Planning Application R/90/18/HH, 9 Park Drive, Rustington.

Further to my letter dated 5th July 2018 in respect of planning application R/90/18/HH for 9 Park Drive, Rustington, I have been informed that further plans have now been submitted which lower the proposed roof line to the height of the current dwelling.

203 Proposed East Elevation

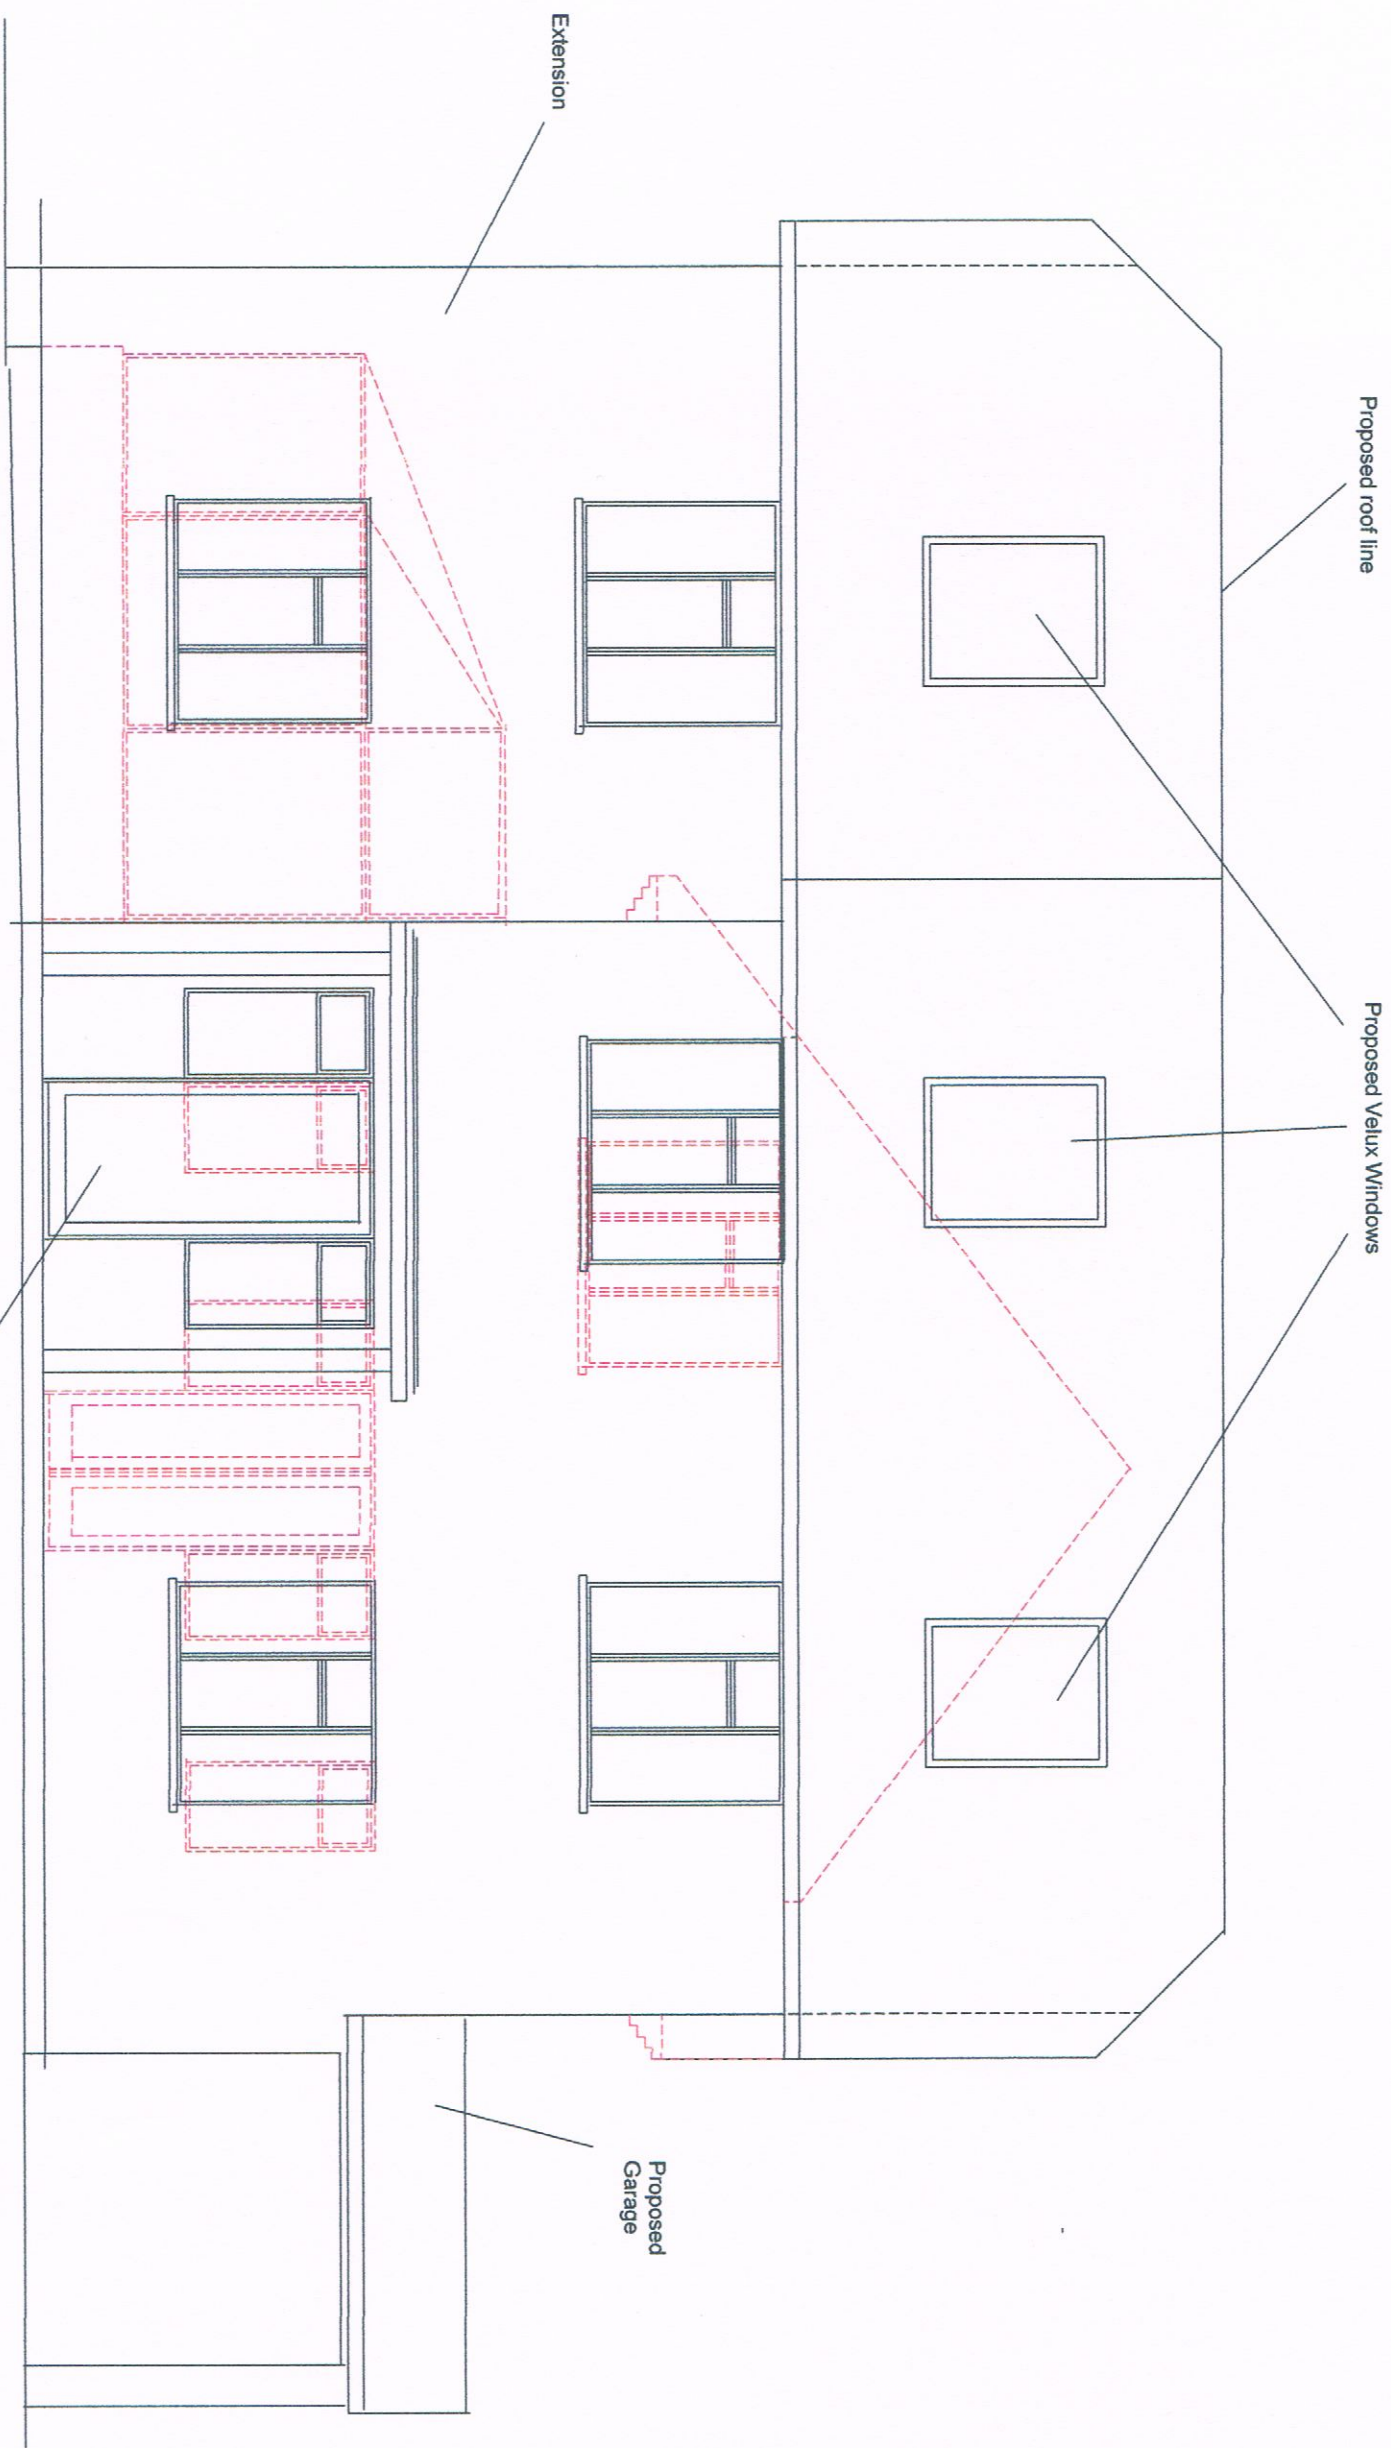
The revised plans may show a minor reduction in the height of the roof line, but it remains a proposed three storey property which will overlook my property from the rear of the 2nd floor. Furthermore, the flat roof balcony area remains, as does the full height patio door which leads to the said balcony.

I am still concerned that the patio doors/windows servicing the flat roof will look directly at my property. Also, the larger windows proposed at either end of the roof, which appear on the drawing to be at a slightly different angle to the Velux windows, will overlook my property to a potentially greater extent than previously.

Although the minor decrease in height of the roof is welcome, it does not significantly alter the principle that this will change from a two storey to a three storey property and overlook my back garden. I therefore still wish to register my objection to this application. In particular, I strongly oppose the window/doors leading out onto a flat roof and the larger windows at each end of the roof, whereby the lower part of the window appears to be vertical and will look over my property.
